**RE: STATE SIGNIFICANT DEVELOPMENT APPLICATION FOR DORAN DRIVE
PLAZA PRECINCT (SSD-15882721)**

School Infrastructure NSW (SINSW) as part of Department of Education (DoE) welcomes the opportunity to provide comments on the public exhibition for State Significant Development Application (SSD-15882721) for the Doran Drive Plaza Precinct at 2 Mandala Parade, Castle Hill (the site).

GROUND LEVEL PLAN
PROPOSED RETAIL & COMMERCIAL
DORAN DRIVE PRECINCT
DORAN DRIVE, CASTLE HILL NSW 2154
FOR DEICORP PROJECTS (SHOWGROUND) PTY LTD
21015 SK 1.04 H

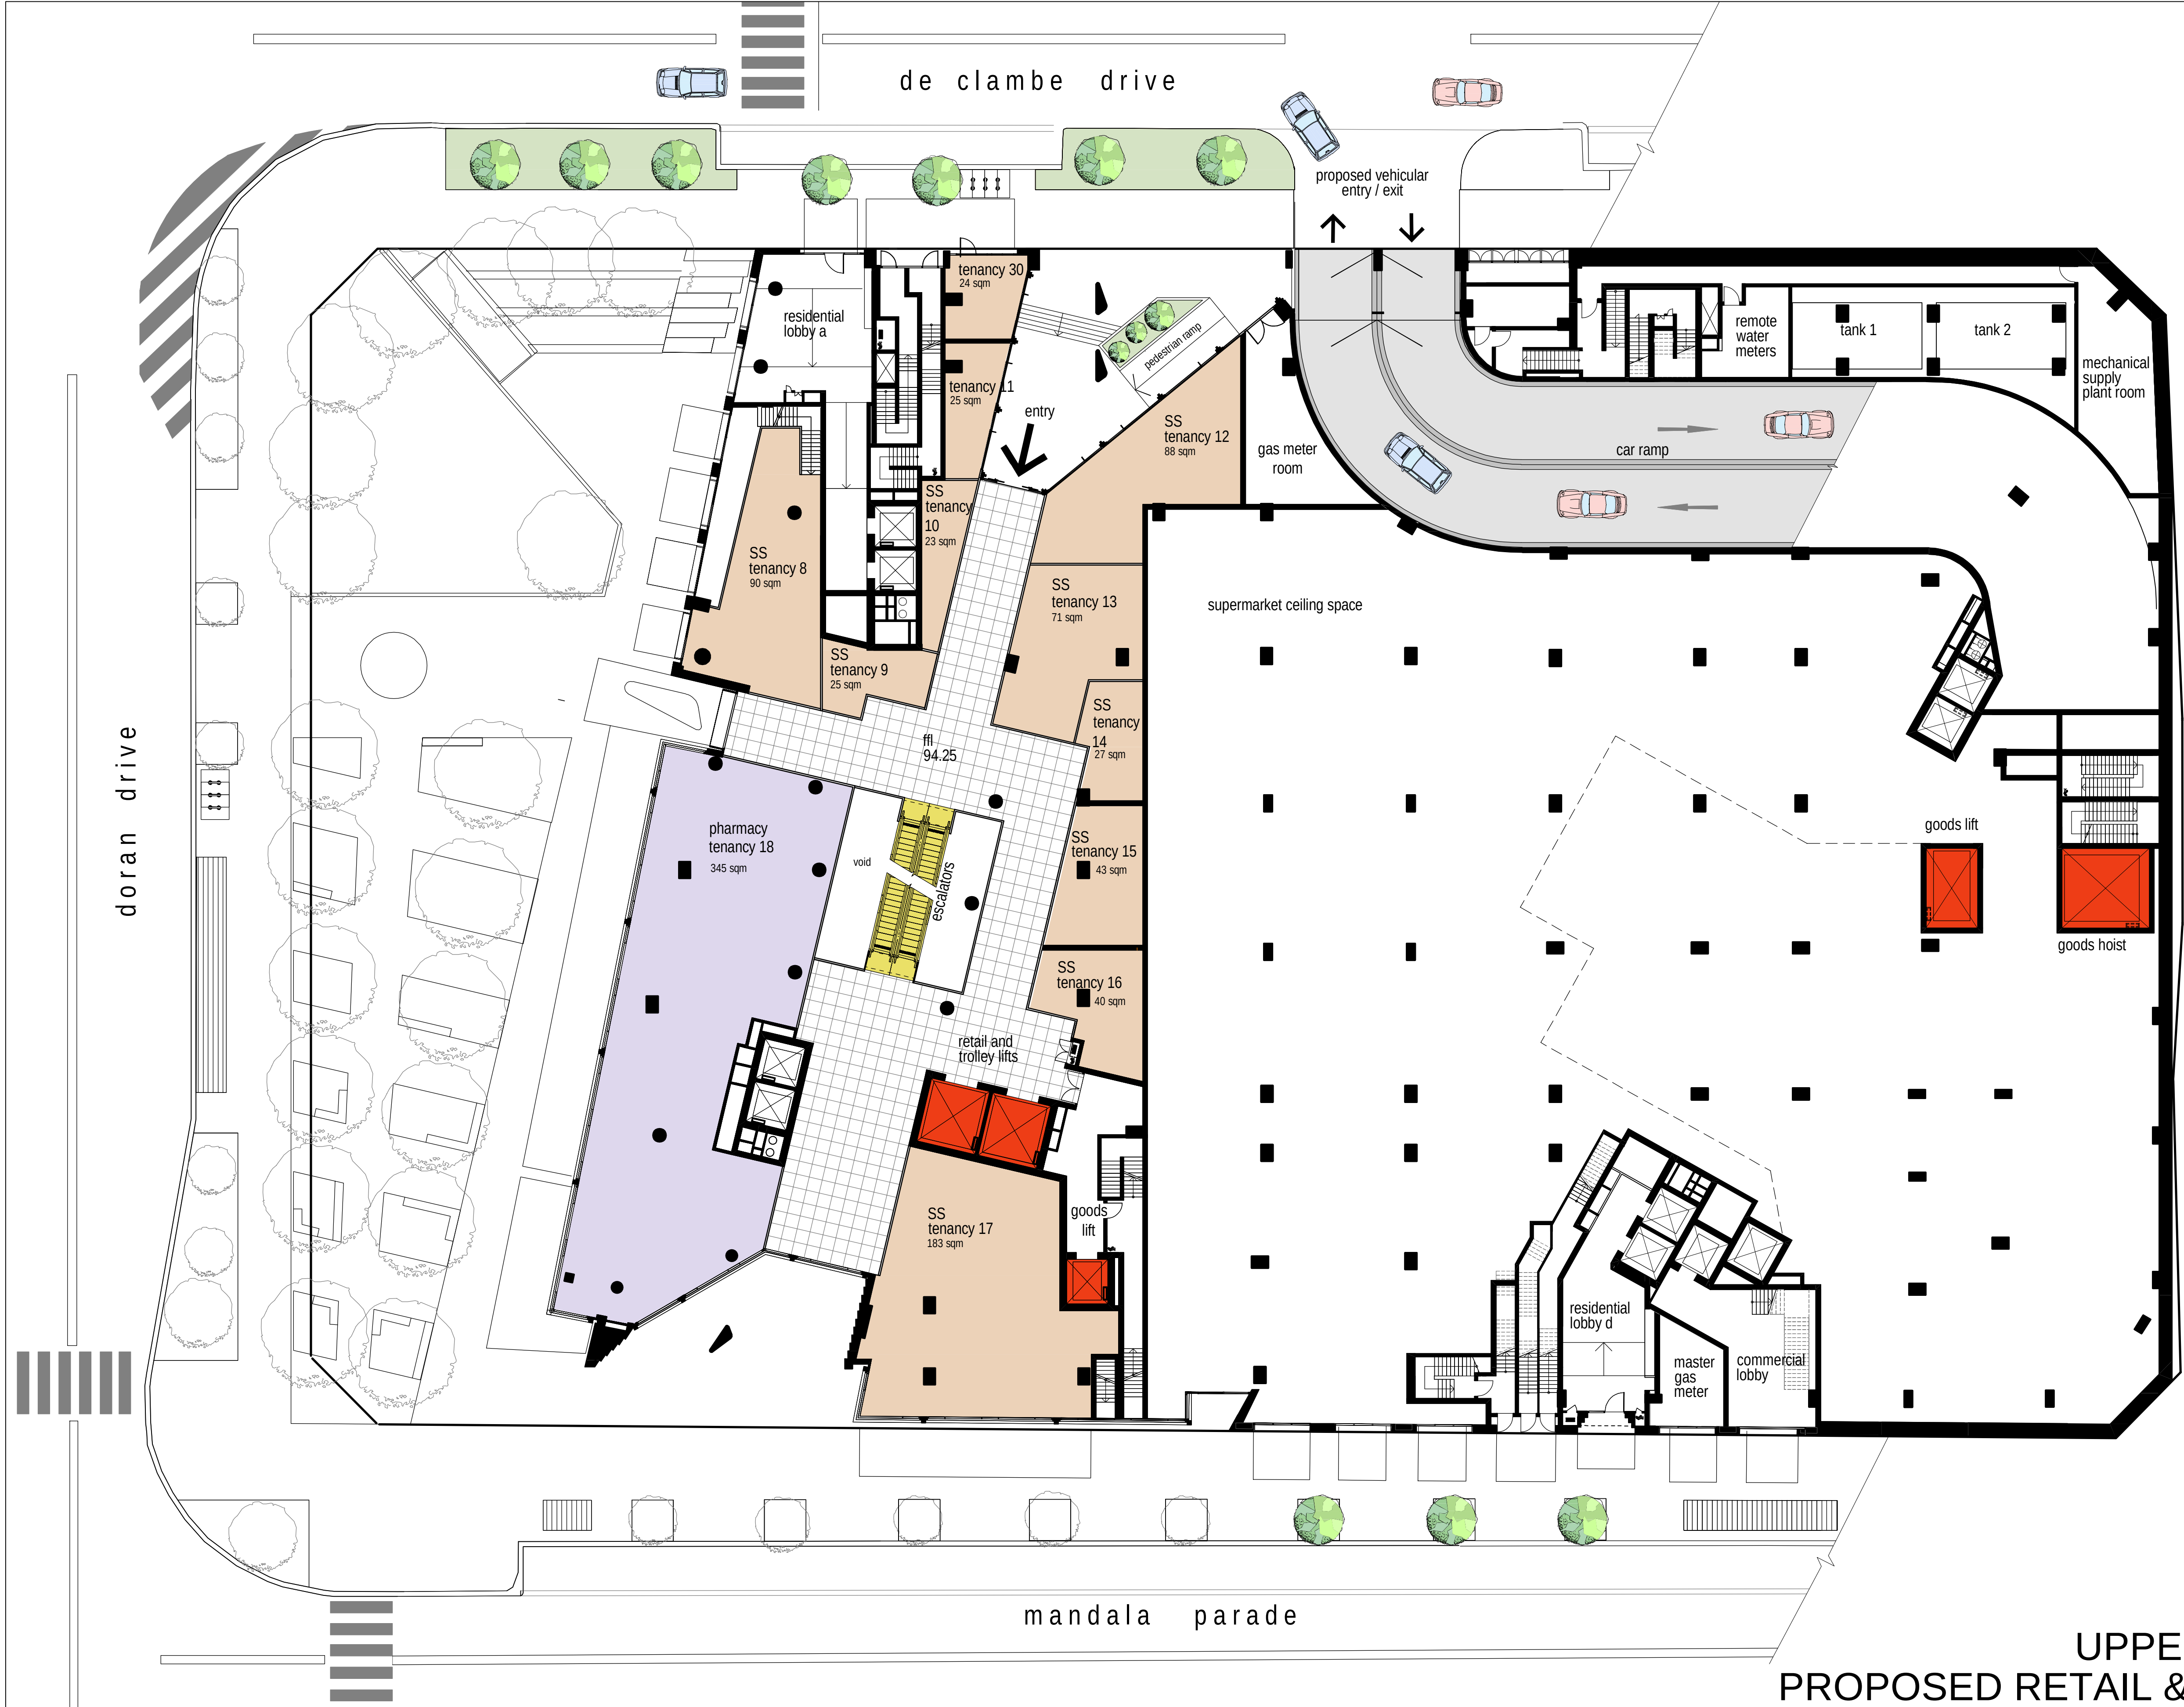
The proposal seeks to provide access to the loading dock via Andalusian Way along the eastern frontage of the site. SINSW notes that Drawing DA-110-010 of the Architectural Plans and the Vehicular Servicing and Management Plan details trucks entering / exiting the loading dock in a forward direction. However, further detail is required regarding measures to manage conflicts between trucks entering / exiting the loading dock and pedestrians utilising the Andalusian Way footpath. SINSW recommends that further review is completed and consideration is made for a pedestrian crossing in this area.

Further, it appears from the Architectural Plans that the mouths of the Andalusian Way and De Clambe Drive driveways are setback within the building line behind the pedestrian pathway, meaning that vehicles entering and exiting the site will not be immediately apparent to pedestrians using the footpath. Conversely, pedestrians will not be immediately visible to vehicles exiting the site. As a result, this could be dangerous to pedestrians surrounding the site. As above, it is recommended that the applicant further considers the interaction between vehicles and pedestrians for these driveways.
